Your Ref: OWQC21192
Our Ref: EP/180/18/PL
Please ask for:
Stuart Corbey

Change of use of boat store & sail loft (Sui Generis) to a single residential dwelling (C3 - Dwellinghouse) & part change of use of former dinghy pen to caravan site (Sui Generis)
The Boathouse, 131A Sea Road & Coastal Caravan Park Sea Road East Preston

Thank you for your internet comments made on 22nd January 2019 which has been recorded as **'an objection'** with the comments as follows:

PROPOSED
FRONT ELEVATION

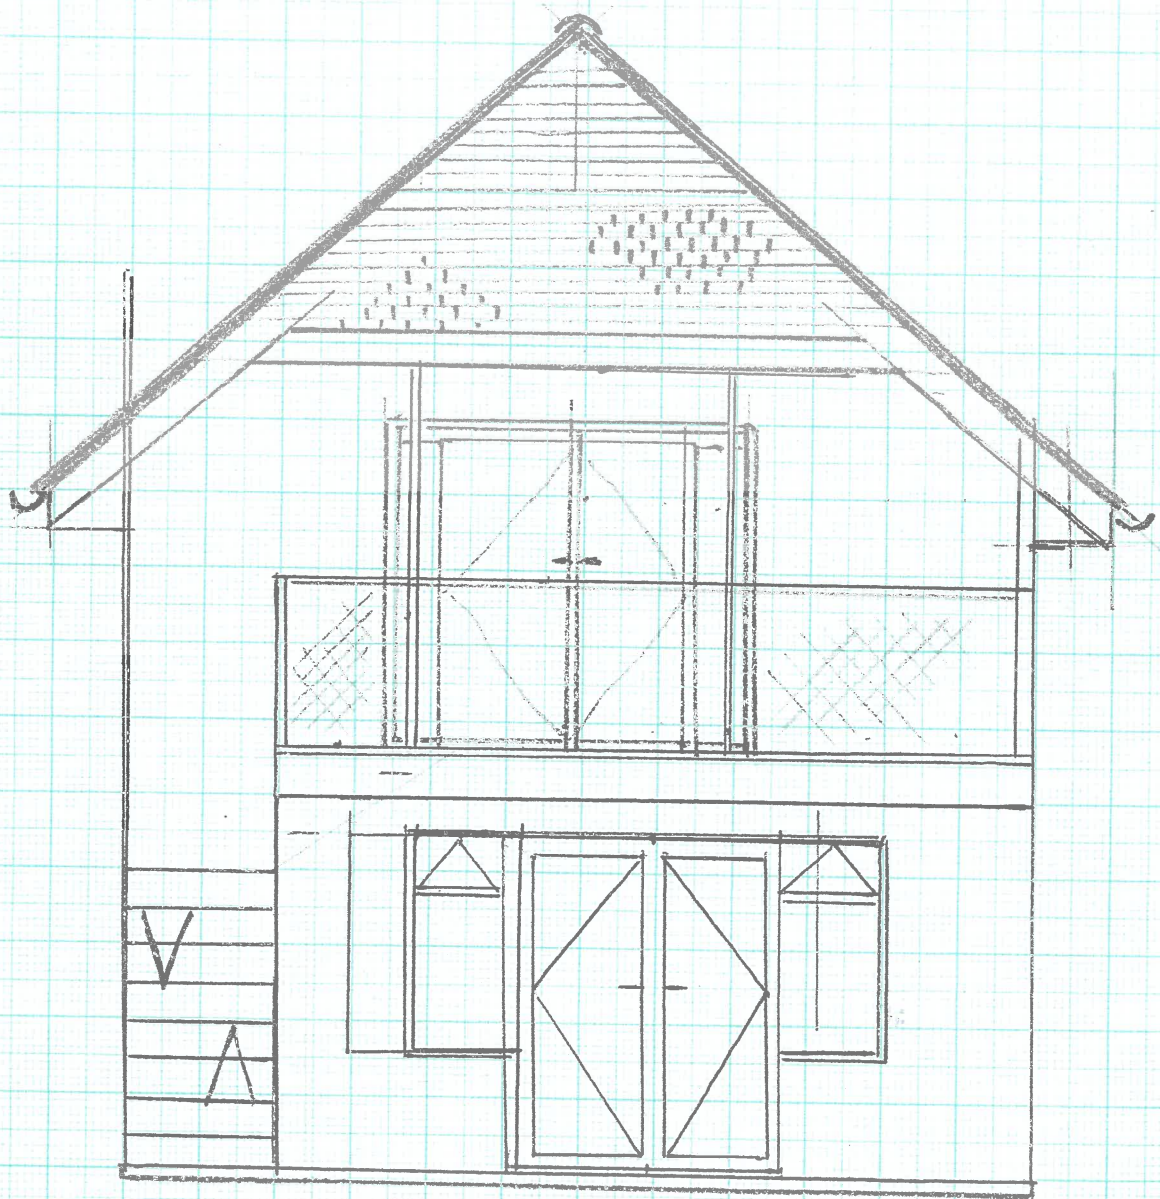
The committee was also concerned about the privacy of caravan site users from the balcony on the southern elevation of this property.
